Please ask for: Mrs D Johnson
Email: daun.johnson@arun.gov.uk
Telephone: 01903 737762
Our Ref: BR/82/22/PL
Your Ref:
Date: 8th April 2022

Application for Planning Permission

Development: Demolition of warehouse and proposed construction of 10 self contained apartments. This application is in CIL Zone 4 (Zero Rated) as flats.
Location: Holmlea, Main Unit Rear Of Town Cross Avenue Bognor Regis PO21 2DN

Proposed Apartments Planning
Date March 2022
Scale 1:200 1:1250

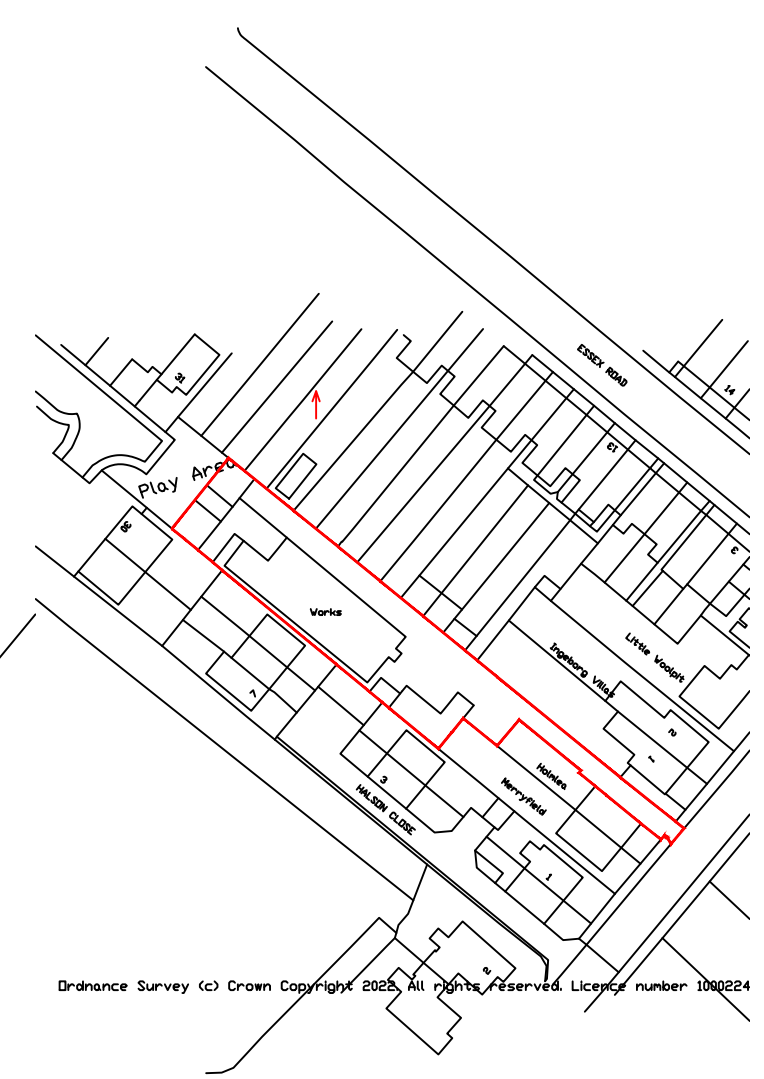
On the location/block plan please provide a north point.

On the existing site plan, please provide a north point.

On the proposed site plan, please provide a north point, dimensions from the proposal to the site boundaries and show the outline of the demolished building.
